Re Planning Application 3/2021/0661("the Application")

I write further to your letter dated 6th July 2021 please treat this letter and its enclosures as my formal representations and objection to this planning application.

UNITED UTILITIES WATER COMPANY
 HAWESWATER AQUEDUCT RESILIENCE PROGRAMME
 RIBBLE VALLEY BOROUGH COUNCIL
 (MARL HILL SECTION)
 EXISTING SITE LAYOUT - SHEET 2 OF 2
 PROPOSED BRADDUP COMPOUND

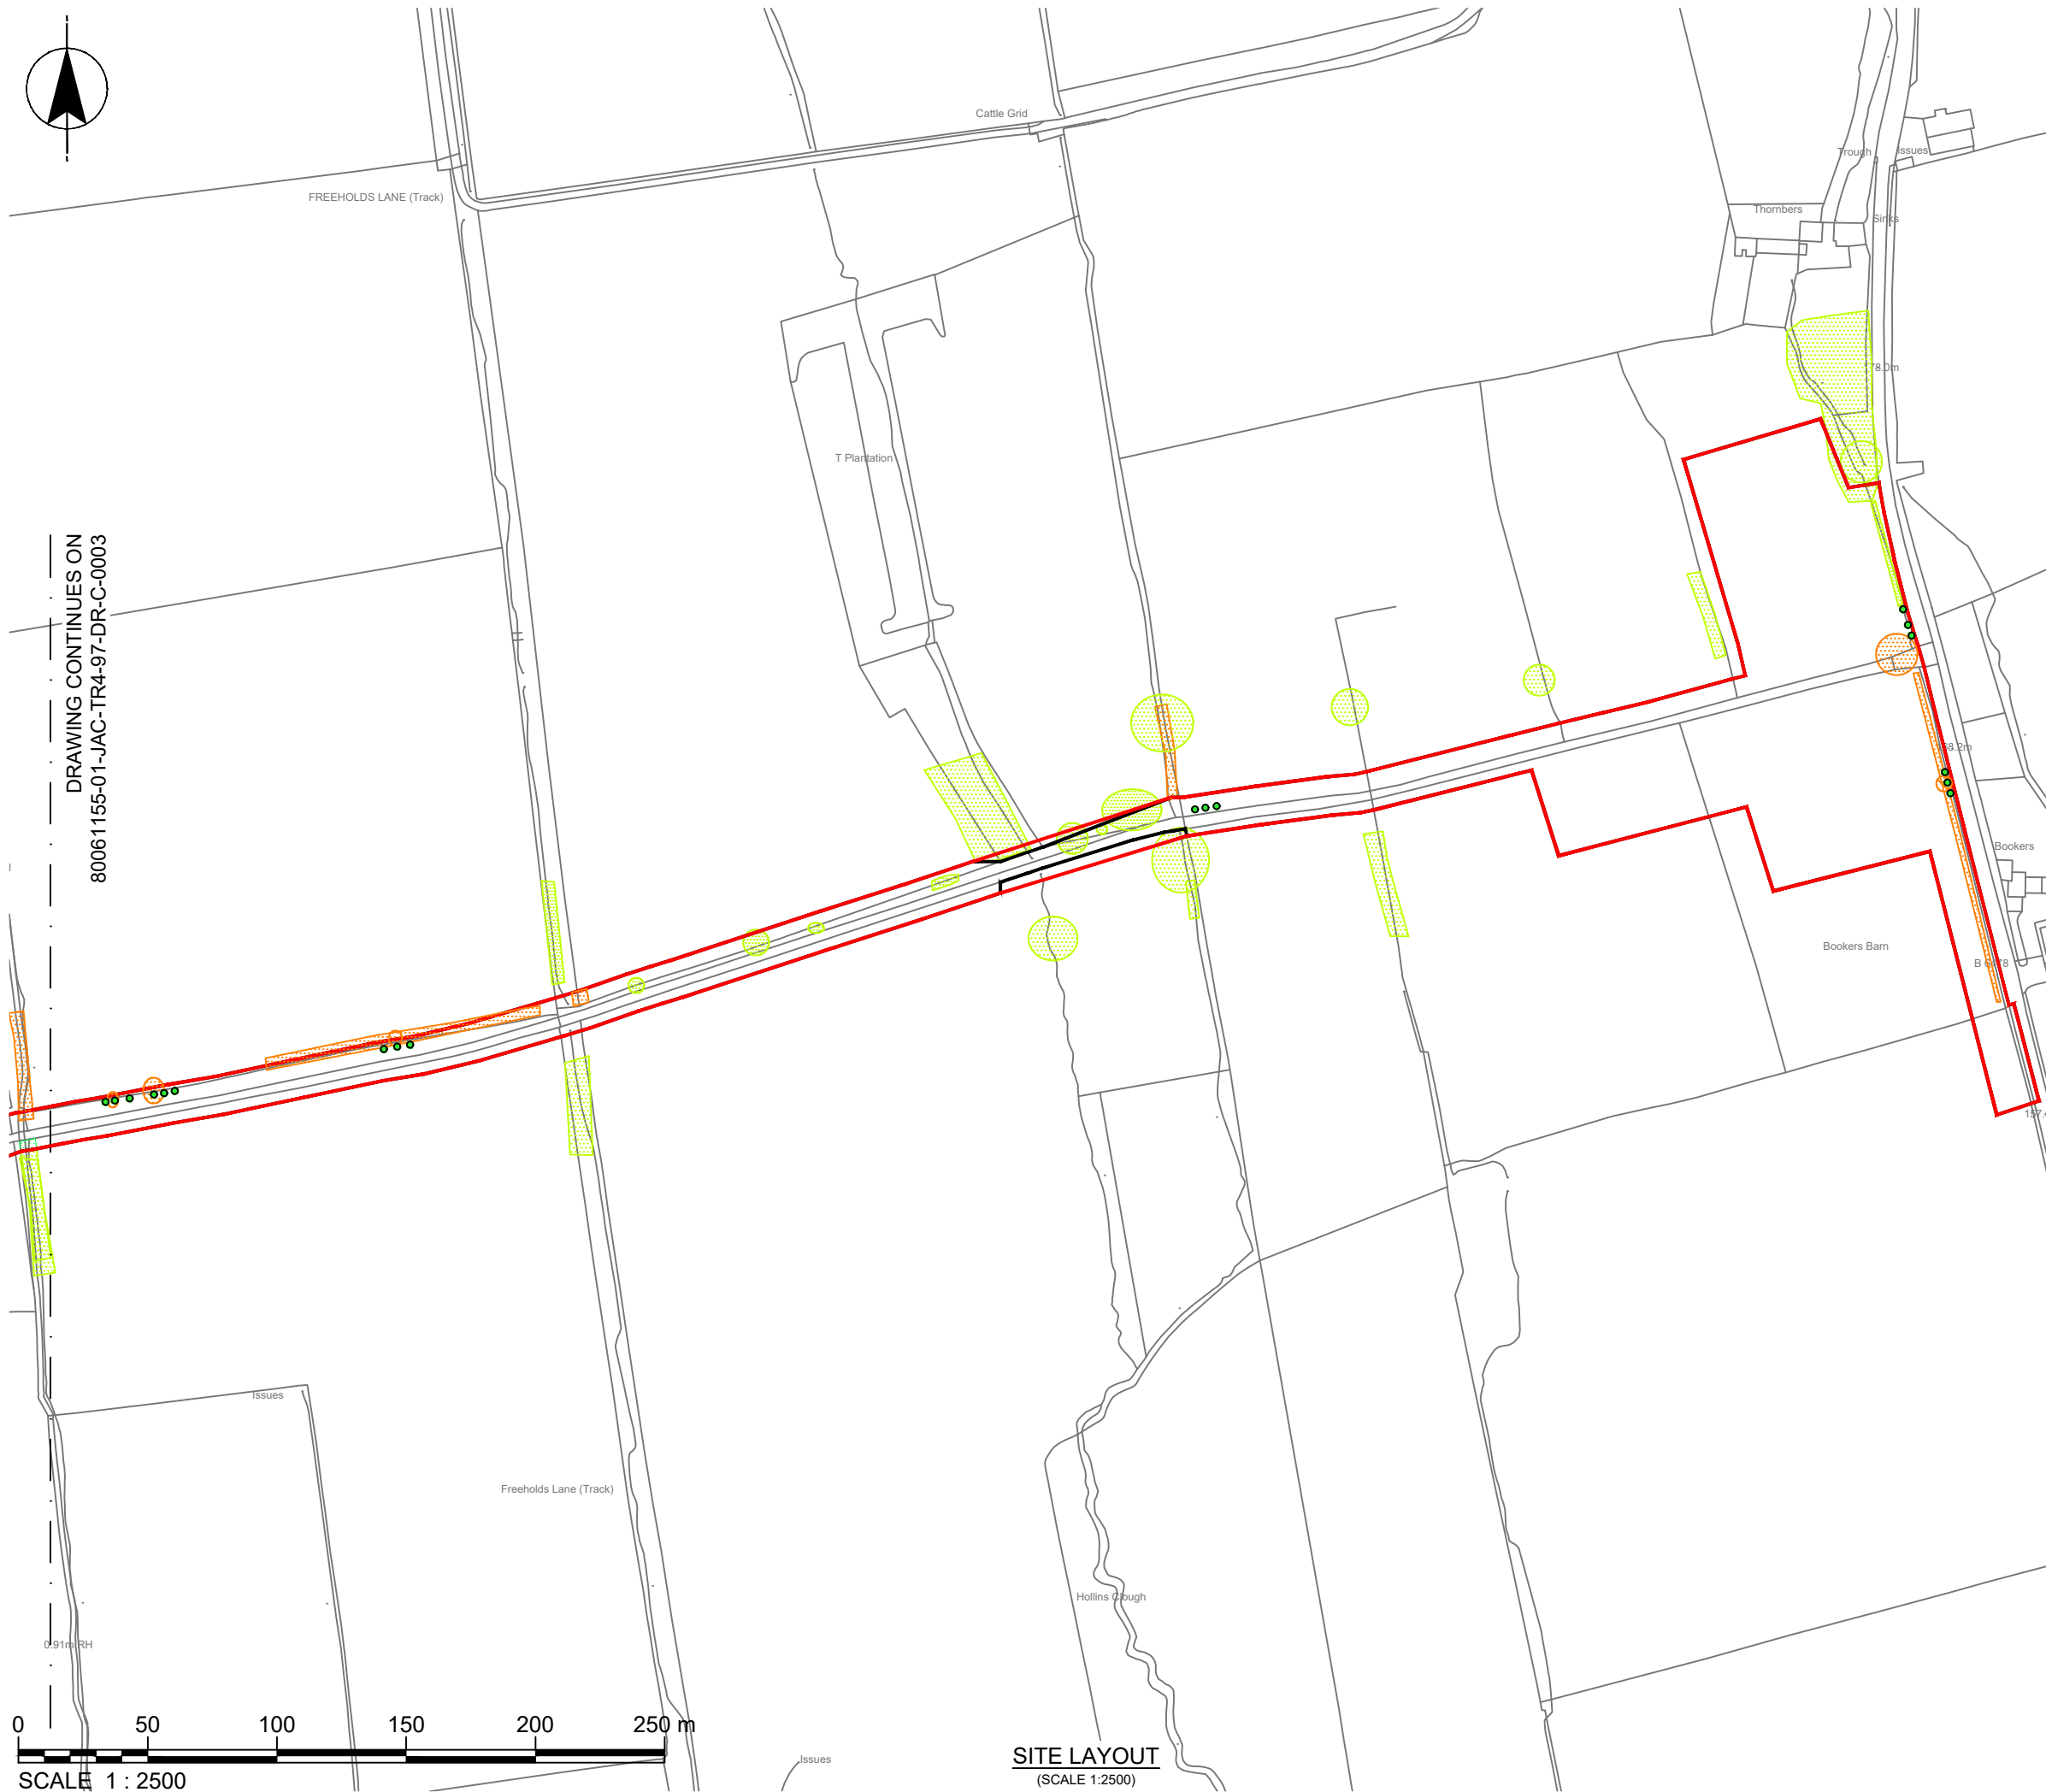
Despite this the plans produced in support of the Application are not accurate. Bradded Compound Existing Site P (**Environmental Masterplan 4 of 4**) does not show any of the existing woodland and other vegetation located [REDACTED] [REDACTED] even though a large proportion of this will be located within 10M of part of the development). Hedgerows are to be afforded priority status and yet large sections have been disregarded in the ecological surveys. This means that the baseline does not take into account the impact of the project on the areas immediately surrounding the sites, for example the Hedge described as TR4.H12 in Onsite Habitat Compensation pdf is exactly the same as the hedge across the road (albeit TR4.H12 is in worse condition and is less diverse). The hedge across the road has not been surveyed or considered from an ecological stand point, despite the fact that it is within yards of one of the busiest access points required for the project. The wildlife living in that hedgerow is ignored for the purposes of the net diversity study. This is not correct, if that habitat is disturbed as a result of the increased traffic (which it is accepted that it will be elsewhere in the planning application as the impact will be felt on [REDACTED] which is further away from the site) but the ecology has not been measured so no one can know what remedial work actually is required.
